Ann Ronay  
Unit 110  
141-143 McEvoy Street  
Alexandria  
NSW 2015

29 January 2018

**Re: Development Application SSD 8373 – Alexandria Park Community School Redevelopment, Park Road, Alexandria 2015**

Drawing Title  
**PROPOSED SITE PLAN**

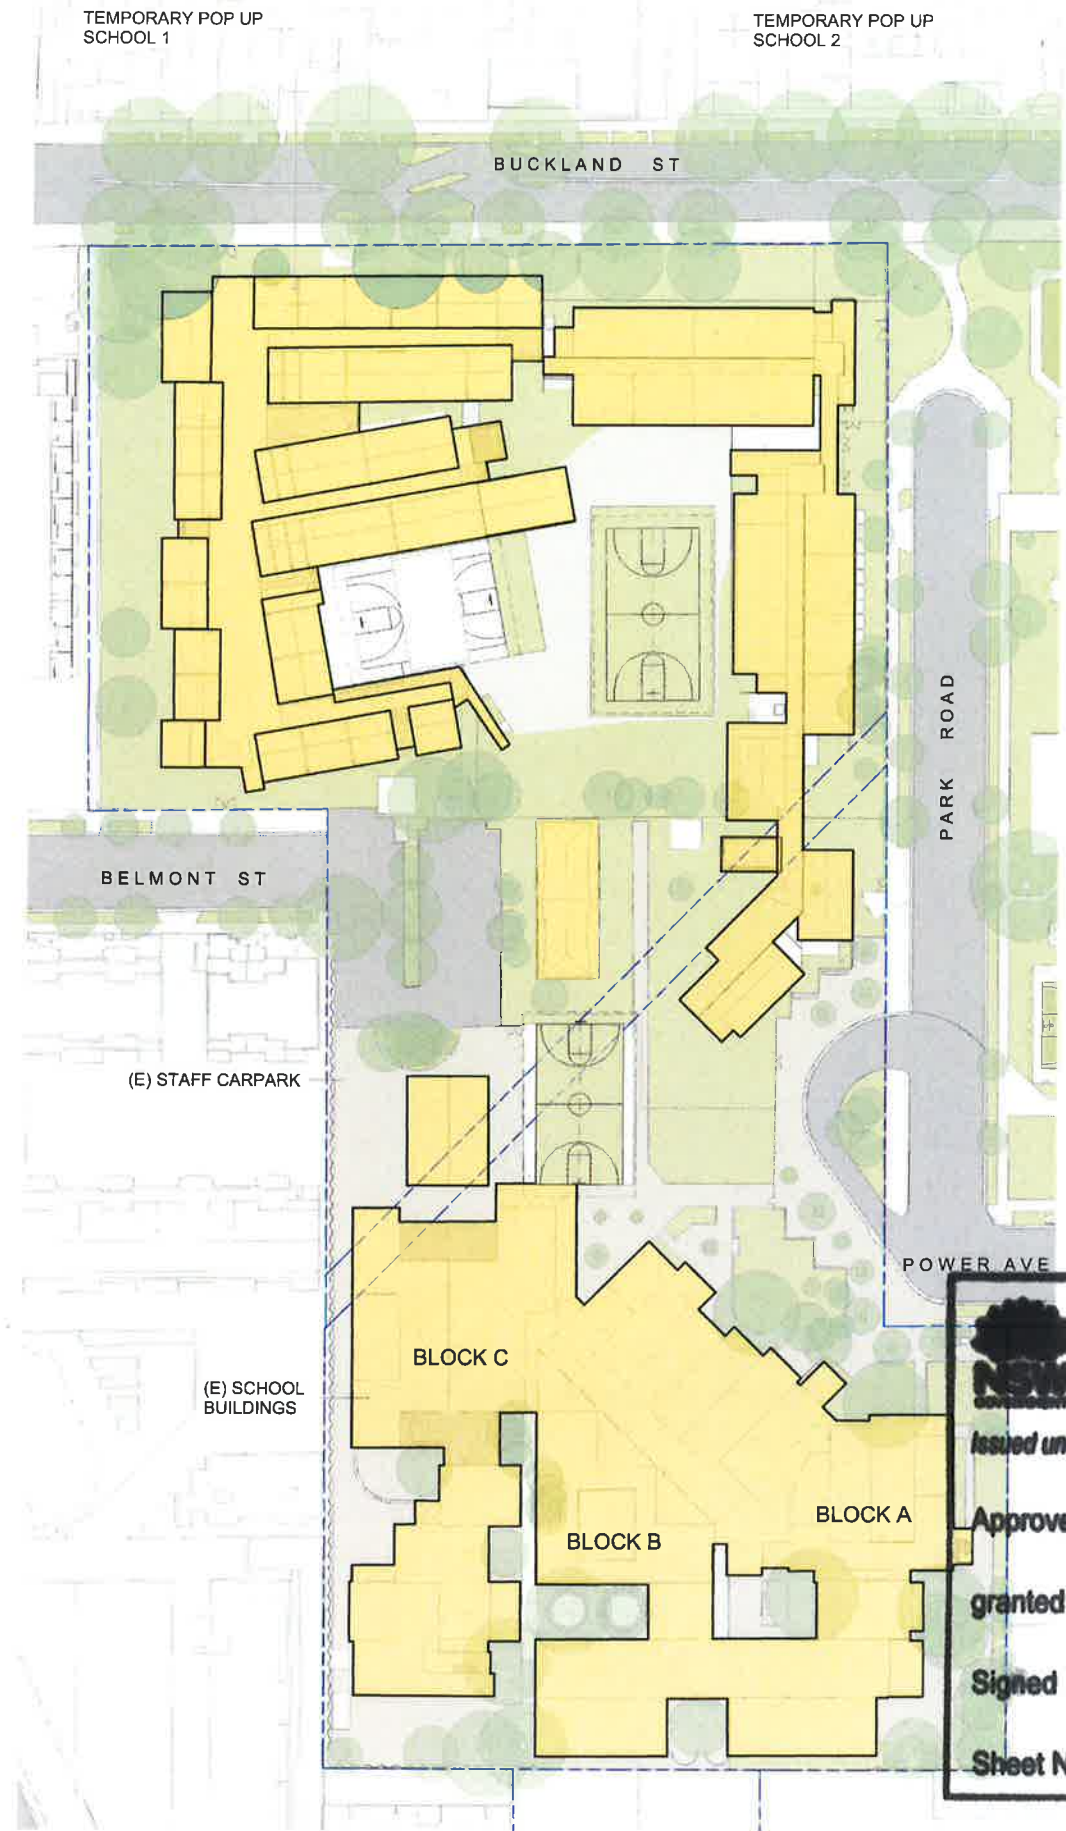
By creating a green zone along the Buckland Street boundary, the proposed new school buildings are 'arranged along the western & southern boundaries of the site. There are no documented envelope controls. To residents living along the south & west boundaries, this feels like an overdevelopment & saturation of the southern end of the site when there is so much land available to the north, where local residents would not be so severely affected. The excessive site coverage to the southern end of the site would dominate the private spaces and adversely impact our lifestyle. We request the southern boundary setback be increased and the buildings be distributed more equitably over the site.

By creating a green zone along the Buckland Street boundary, the proposed new school buildings are 'arranged along the western & southern boundaries of the site. There are no documented envelope controls. To residents living along the south & west boundaries, this feels like an overdevelopment & saturation of the southern end of the site when there is so much land available to the north, where local residents would not be so severely affected. **The excessive site coverage to the southern end of the site would dominate the private spaces and adversely impact our lifestyle. We request the southern boundary setback be increased and the buildings be distributed more equitably over the site.**

Drawing Title:  
**THIRD FLOOR PLAN - SOUTHERN HUBS**

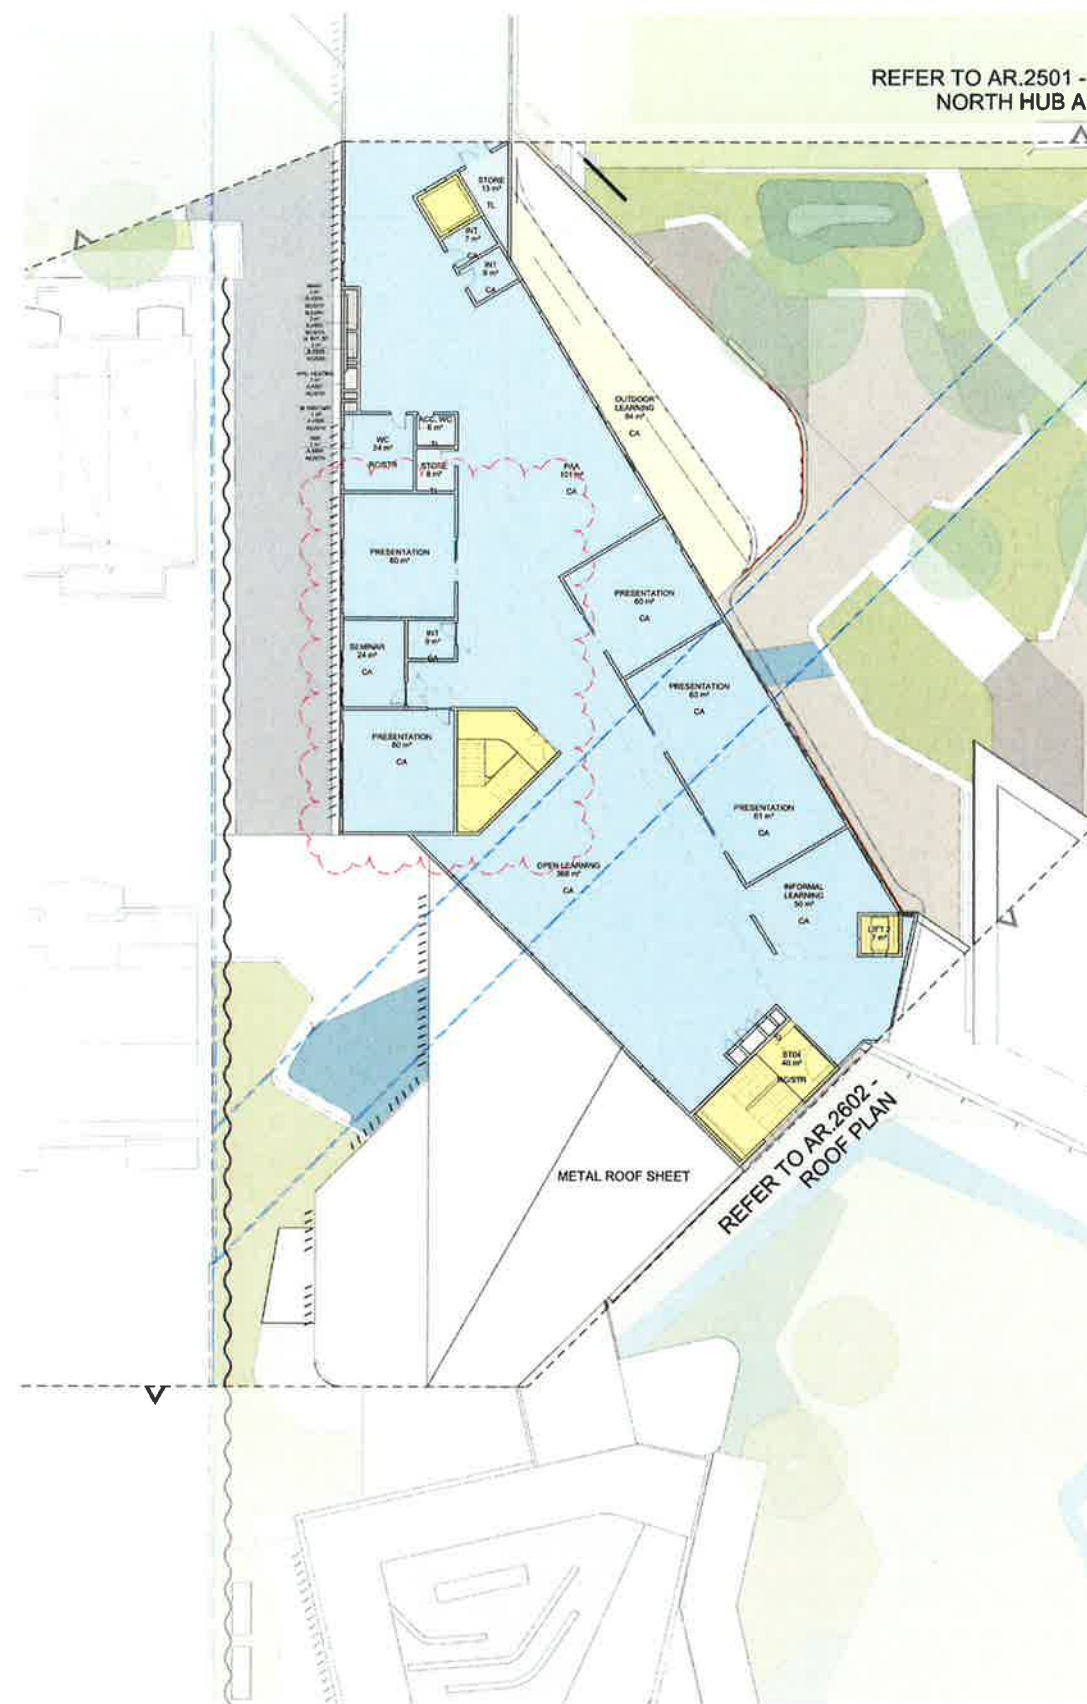
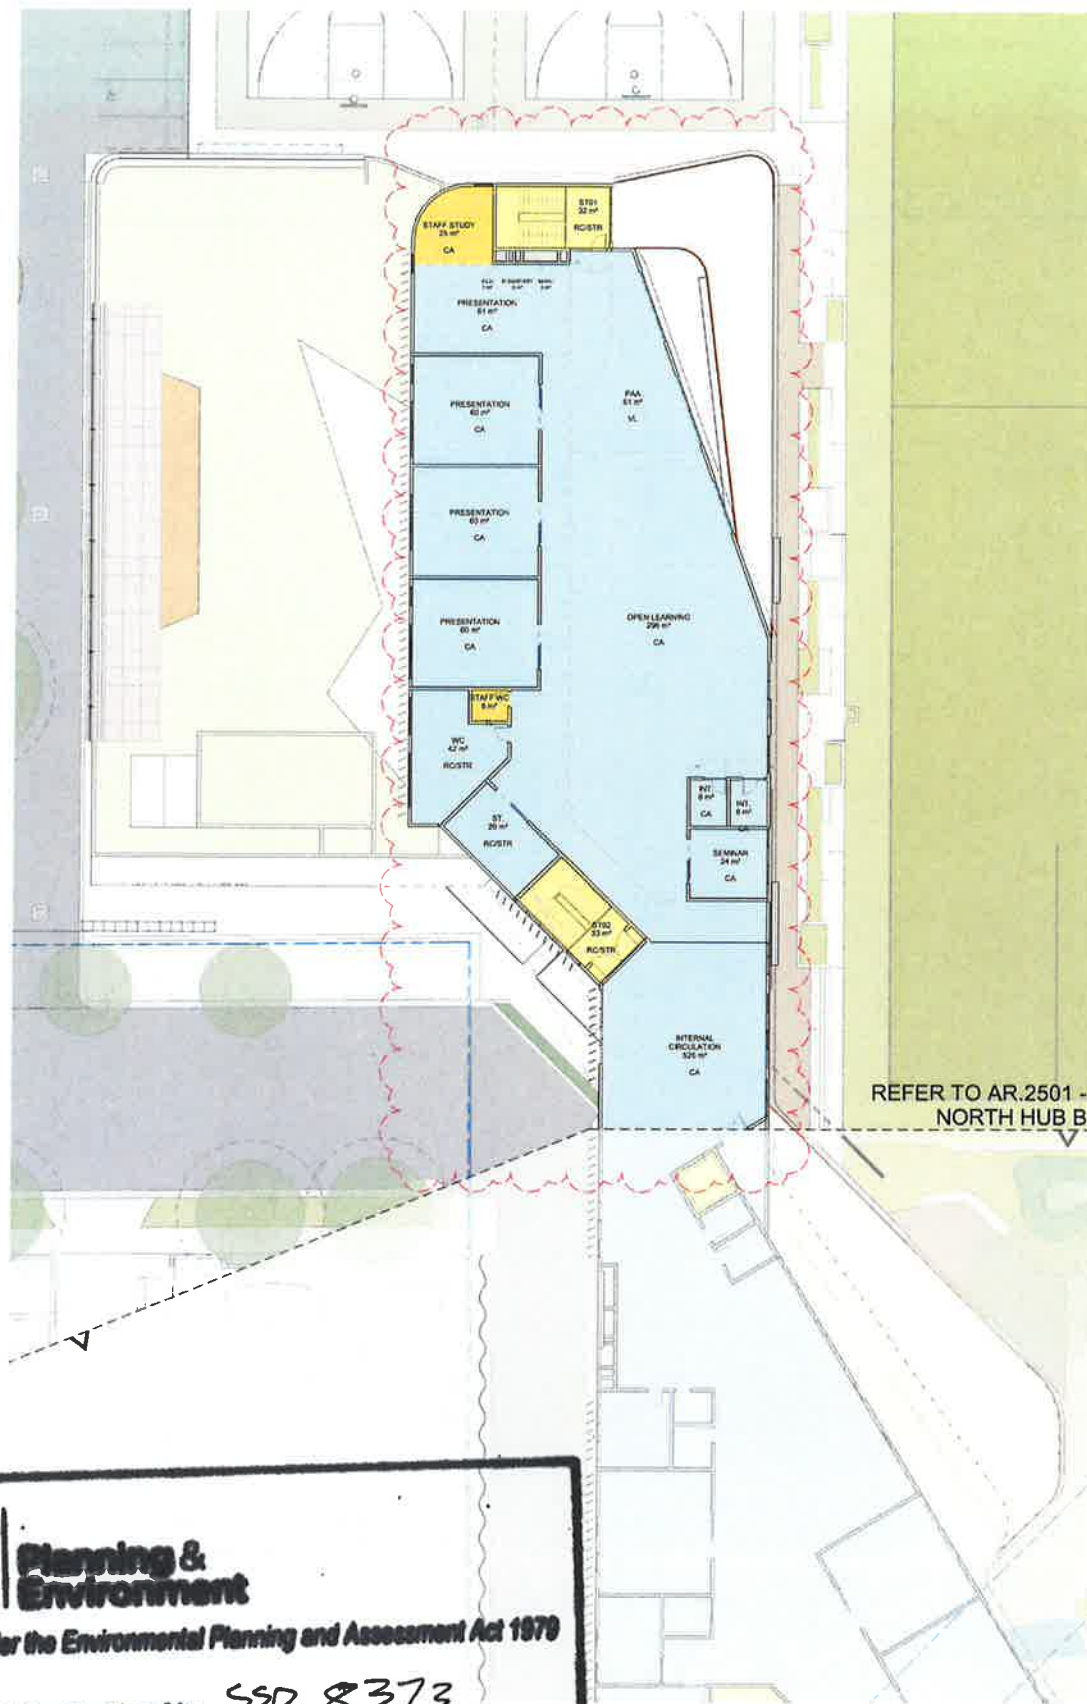
The proposed buildings are in excess of the L.E.P. zoning height controls. I feel that the impact on the residential building 141-143 McEvoy Street (southern end) has not properly been considered as to the affects as far as shading, light and privacy. The diagrams show that the proposed southern building of the school has 3 storeys but with a 'rooftop

playground' which itself has a roof, this actually makes it 4 storeys. ***The living areas of my property and the 5 adjacent units actually sit approx 2.4m below the ground level of the school increasing the impact of the height of the new school in relation to my property. I seek the removal of the 'rooftop playground' due to the impact on privacy.***

The Environmental Impact Statement states the "impact will be minor" which I disagree with, the proposed buildings along the southern boundary are excessive in density & in height, the roof top playground alone is over 2000sqm in area alone. We seek the removal of the roof top play area to reduce the height and mass of the facade.

Noise generation poses a significant loss of amenity to the southern and western residents. For that reason, we request the removal of the ground level 'canopy class room' on the southern corner and the removal of the rooftop playground on the southern hub.
